WEST SUSSEX COUNTY COUNCIL CONSULTATION

TO:	Arun District Council FAO: Mr. David Easton
FROM:	WSCC Highways - Public Rights of Way
DATE:	16 March 2022
LOCATION:	Land at Bilsham Road Yapton
SUBJECT:	Y/13/22/DOC Approval of details reserved by condition imposed under Y/91/17/OUT relating to condition -Construction Environment Management Plan.
DATE OF SITE VISIT:	n/a
RELEVANT PUBLIC RIGHTS OF WAY NUMBER(S):	FP156-1, FP156-2
RECOMMENDATION:	Advice
S106 CONTRIBUTION TOTAL:	n/a

Figure 3: Proposed Public Right of Way Diversion

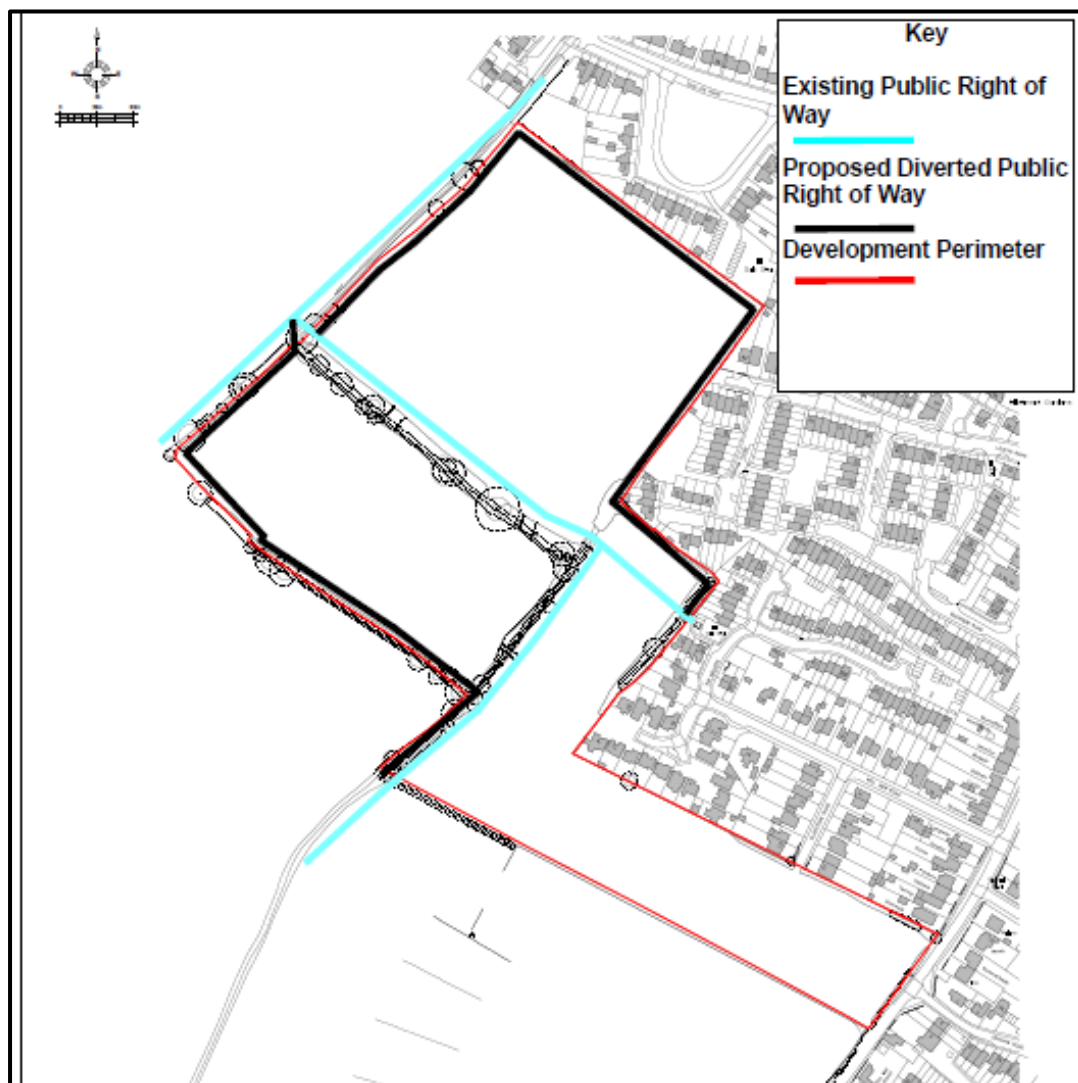
- the developers keeping PRoWs FP156_1 and FP156_2 open for public use as long as possible, and
- Site Managers checking daily to ensure they are safe, unobstructed and not interfered with by construction works.

With regards to applying for a temporary diversion, should the developers foresee that the legal line of the PRoW will not be available for public use, a Temporary Closure Order must be applied for and approved in advance. Information on this can be found at

The developer will be responsible for any alternative route, appropriate signage and ensuring the path is safe for public use.
